Online Comment

Application H05-0144-18
Location HOLBEACH MANOR 2 FLEET ROAD FLEET PE12 7AX
Proposal Erection of snooker room extension to existing dwelling and garage blocks incorporating annexe accommodation.

Name Ian Marshman
Address Lincolnshire County Council Places Team Lancaster House 36 Orchard Street LN1 1XX

DRAWING Floor Plans & Elevations

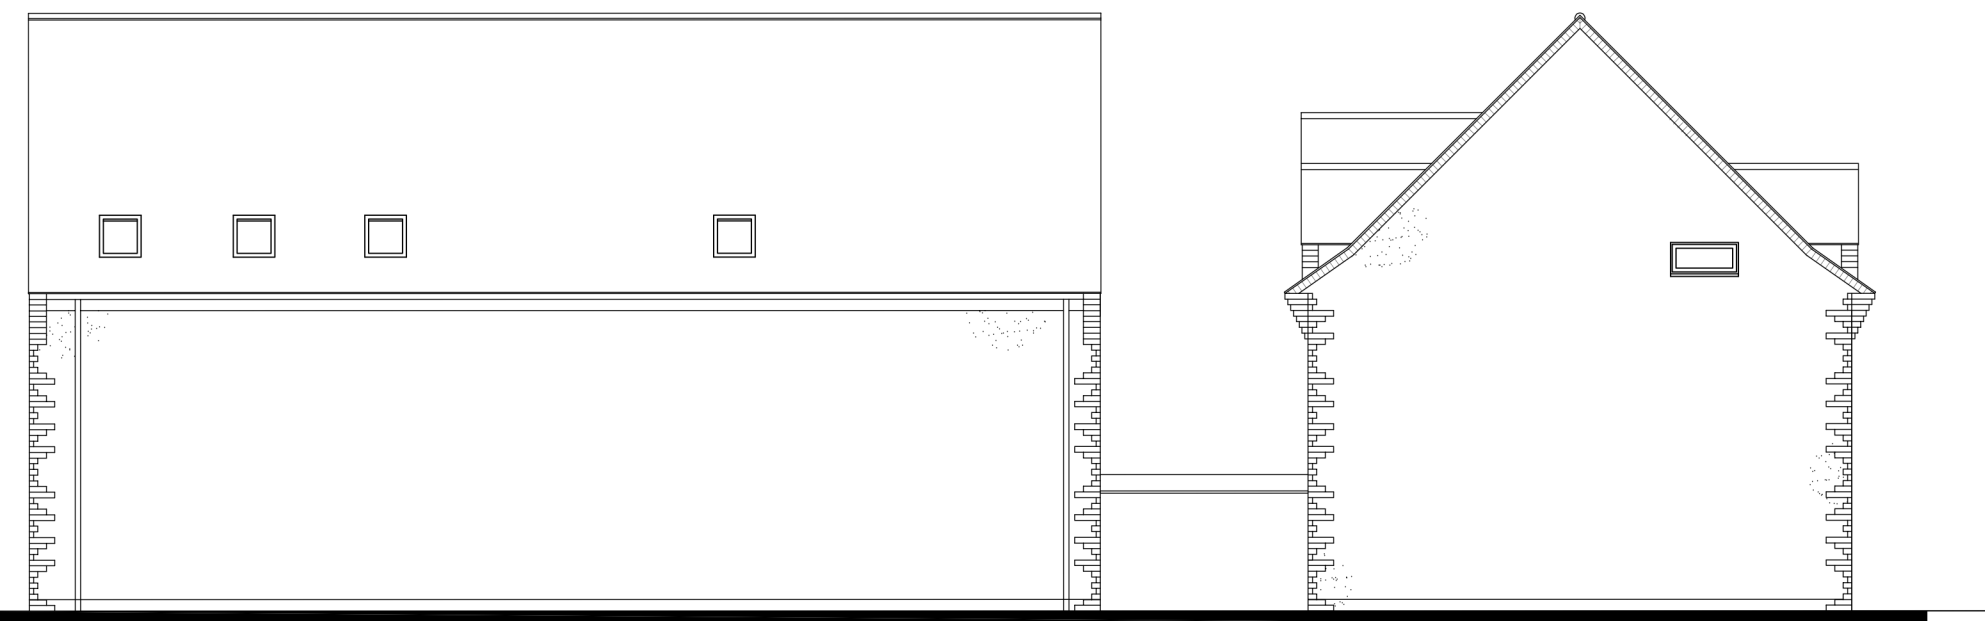
The proposed development is sympathetic in scale and design to the historic main house, and given its location to the side of the property, would not otherwise substantially harm the significance of the house or its historic parkland. However, the proposal to use brown uPVC windows and doors in the residential extension and garages in an attempt to "match" existing timber and Crittall steel in the main house would represent harm to the setting and significance of this currently well preserved non-designated heritage asset.
